Response to Request for Additional Information (SSDA 10365)

This table relates to a request for additional information relating to SSDA 10365 at St Francis Catholic College.

Project Name: EDMONDSON PARK MASTER PLAN
130-160 JARDINE DRIVE EDMONDSON PARK NSW, 2174
Drawing Title: EXISTING SITEPLAN/SOIL & WATER MANAGEMENT
Scale: 1:500 @A1
Date: 11/05/2020
Project No: 1130
Drawing No: SSD12
Rev: 01
Status: SSD APPLICATION

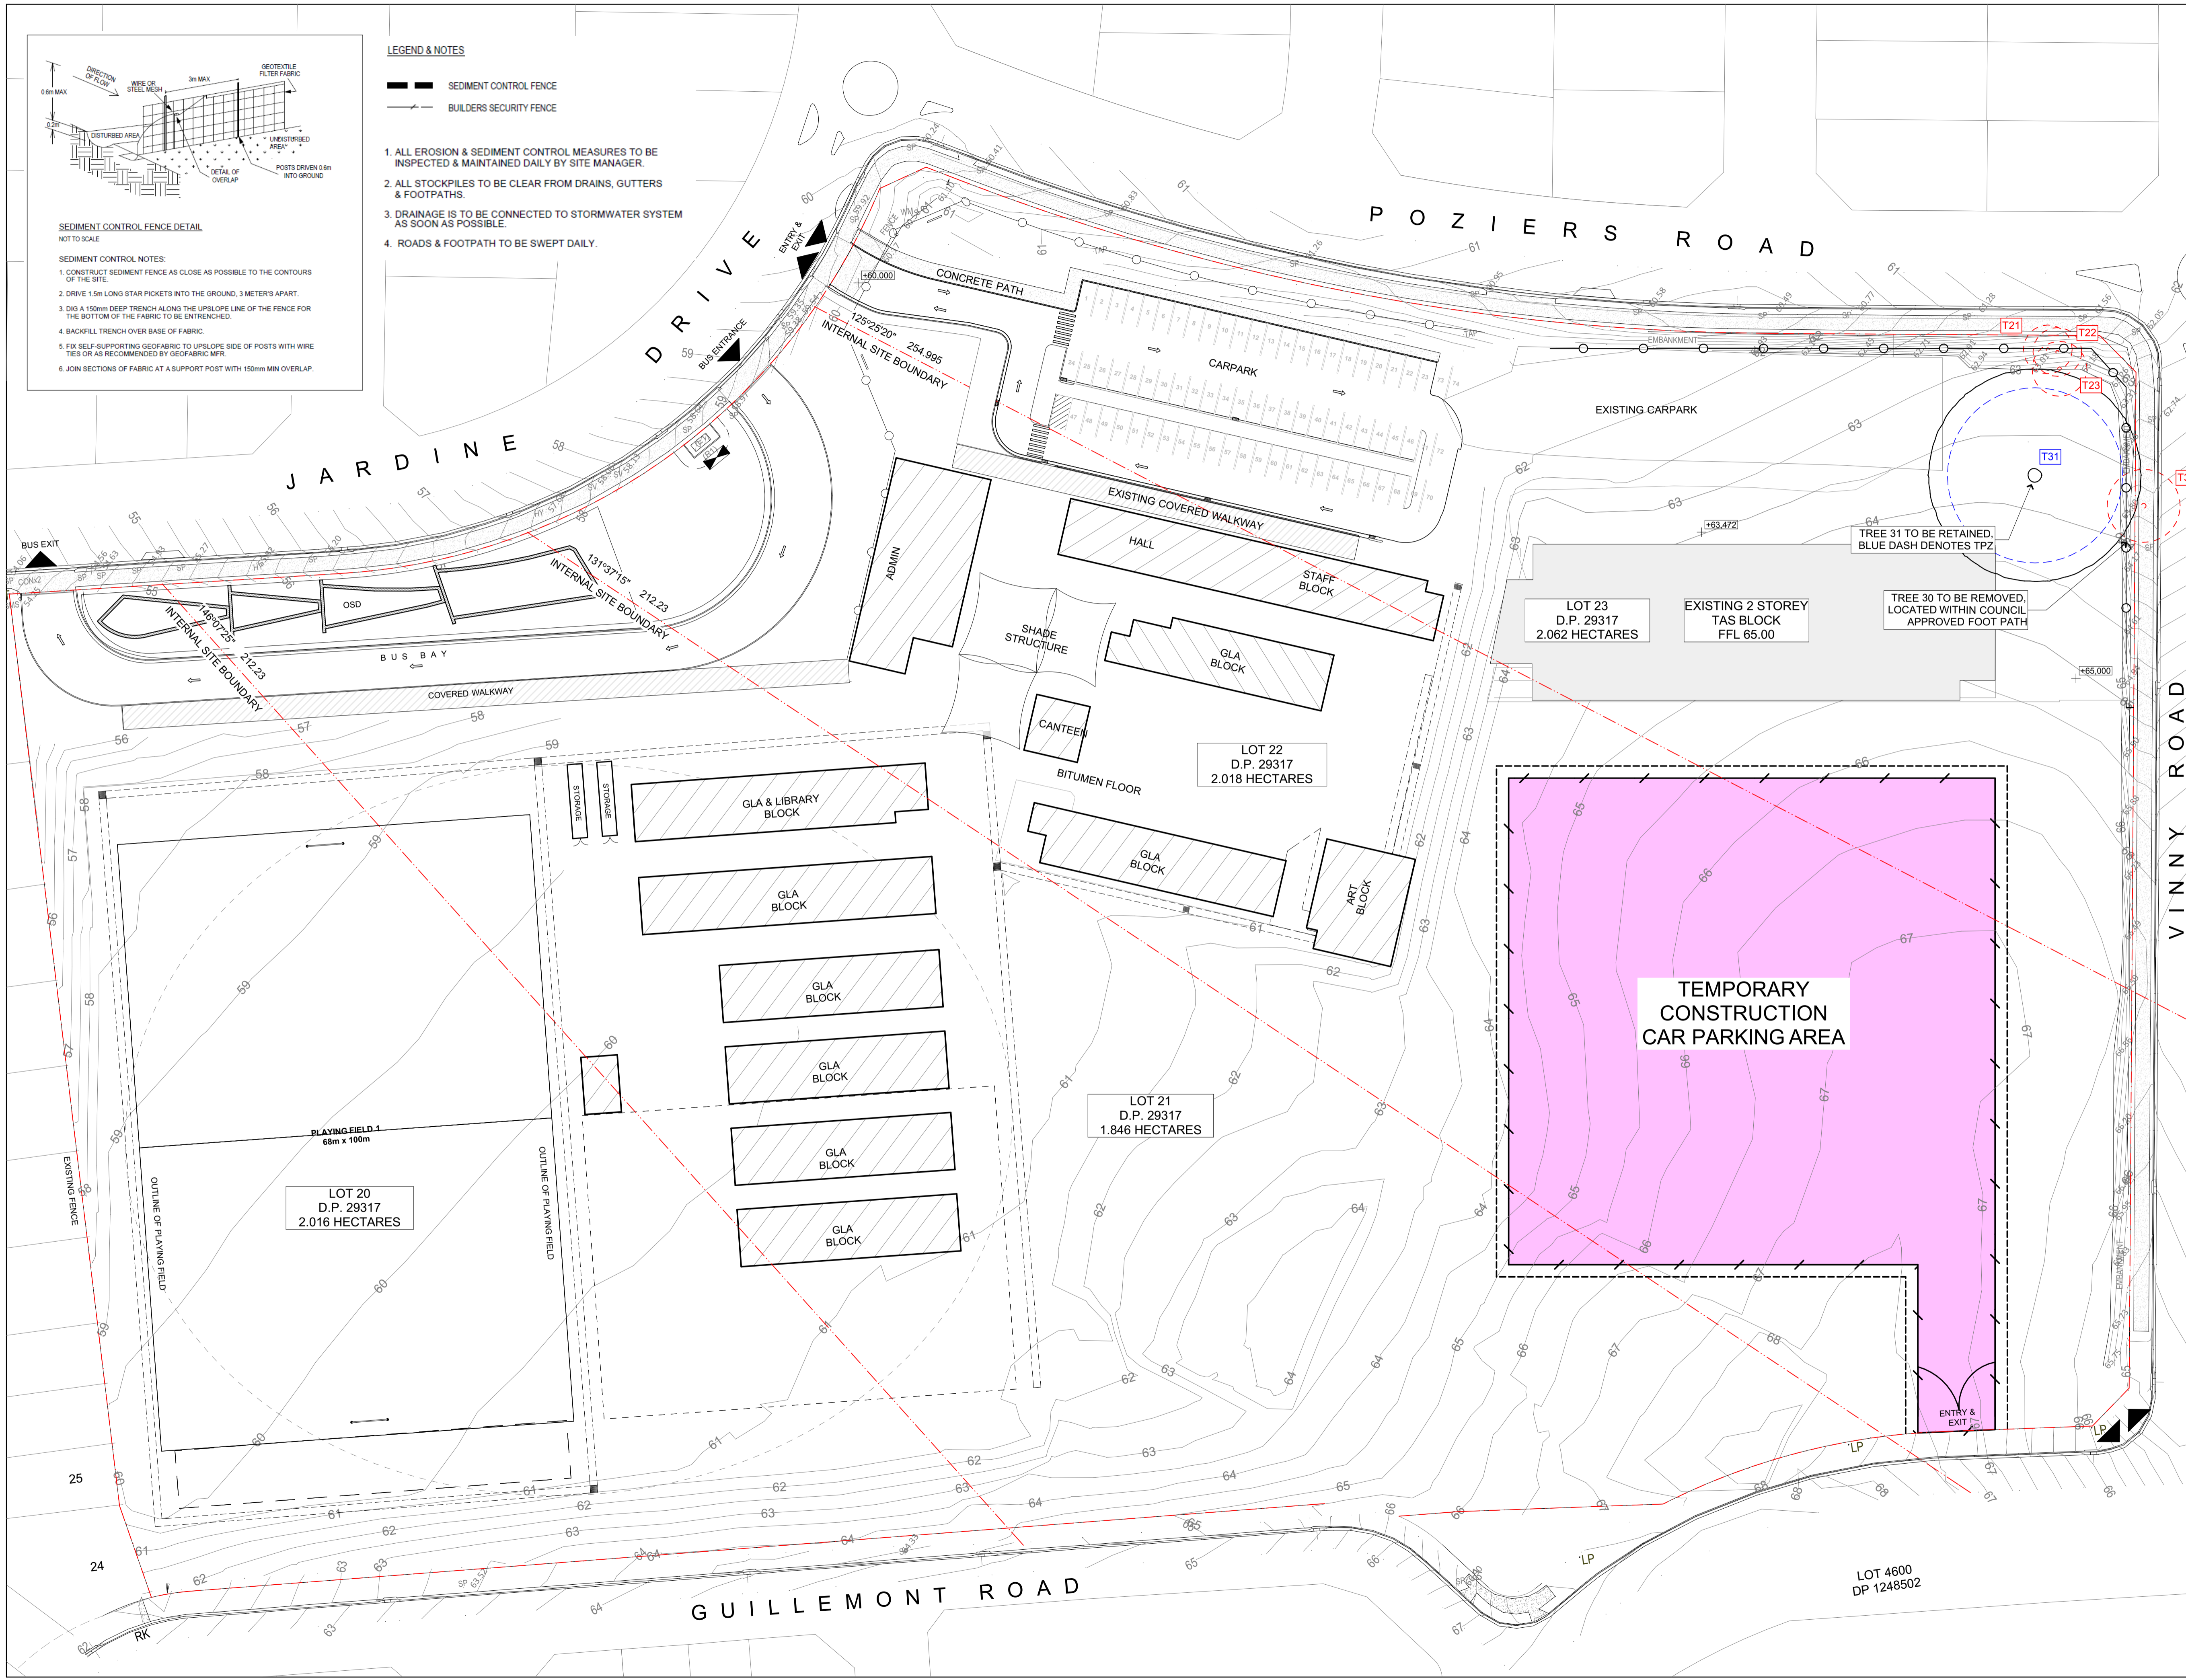
<ul style="list-style-type: none"> The Construction Traffic Management Plan includes reference to the establishment of a temporary on-site car park for construction workers. The EIS main report does not appear to discuss this in detail or describe any site works 	<p>The exact details of a temporary on-site car park will be determined by the lead contractor. The site is large enough to accommodate a temporary on-site car park without unreasonable impacts, particularly with the implementation of erosion and sediment control measures as outlined in the Soil and Water Management Plan in Appendix 16. It is considered</p>	<p>Section 9.7</p>

Matter	Comment	Reference in EIS
<p>required or assess the environmental impacts of any such works. This should be included.</p>	<p>reasonable to determine the exact location of the car park at a later stage as it cannot be determined with sufficient certainty, at this stage, where adequate space for the car park would be available.</p>	
<p>Construction Arrangements</p> <ul style="list-style-type: none"> The EIS and Construction Traffic Management Plan state that a construction program is not available as it would be determined by the head contractor prior to the construction works. A high-level construction program, with overall details of the anticipated construction duration and highlighting any significant and milestone stages and events during the construction process should be provided as required by the SEARs. 	<p>A Construction Program is provided in Appendix 22.</p>	<p>Section 9.8</p>
